DECISION DELEGATED TO DEVELOPMENT MANAGER

Application No: H22-0128-21 **Applicant:** Coda Builders Ltd.

Proposal: Erection of 3 dwellings - approved under H22-0864-19. Change colour of windows, omit canopy above entrance doors (all plots) and omit 3 windows on west elevation of Plot 1

Location: 315 Broadgate Weston Hills Spalding

P r o p o s e d E l e v a t i o n s

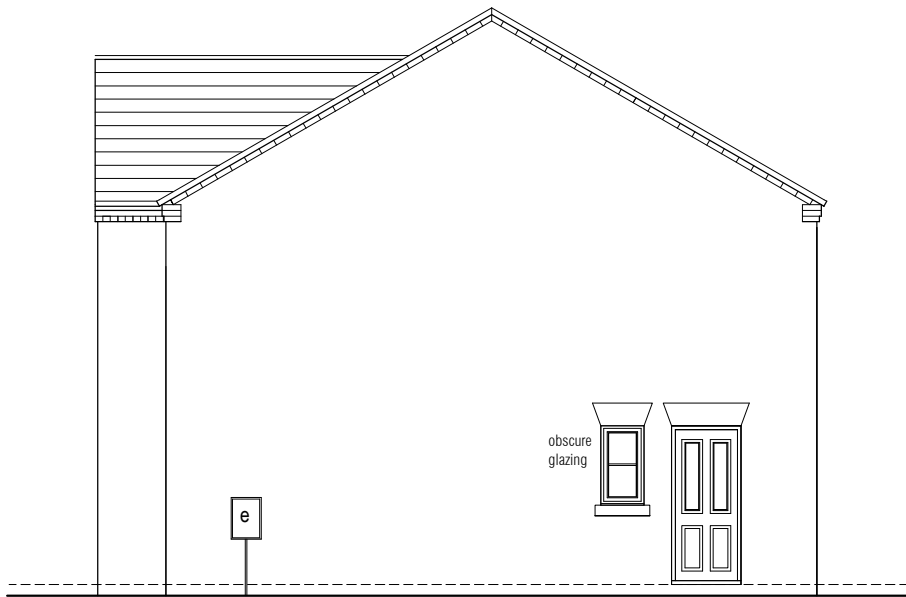
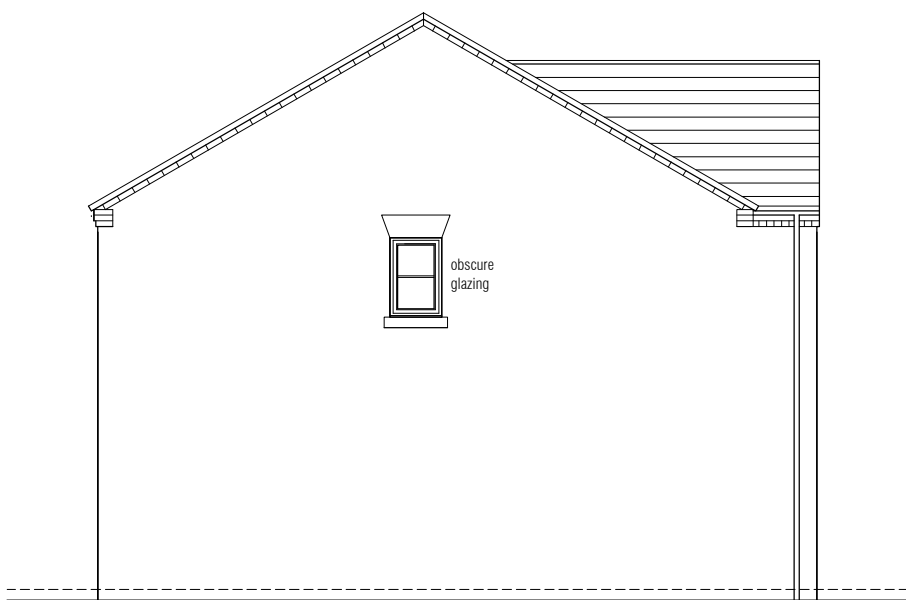
The approved material for the windows of all dwellings was UPVC white. The amendment hereby proposed is to replace white colour for Anthracite grey. No harm would occur upon the visual amenity. It is considered that the dark colour would equally relate well with Vandersanden Flemish Antique facing brickwork. No cumulative impact would occur in conjunction with roof tiles of identical appearance.

The removal of the approved canopy above entrance doors of all dwellings is the second amendment hereby proposed. In fact, the canopy would be replaced by brick lintel matching with those of the remainder of openings. This replacement is not considered harmful upon the overall detailing of the buildings.

Lastly, the windows on western side wall of the house in Plot 1 would be removed other than the first-floor windows for en-suite. This alteration would not decrease the enjoyment of daylight for the future dwelling occupiers. The main windows would remain for living room, kitchen and bedrooms.
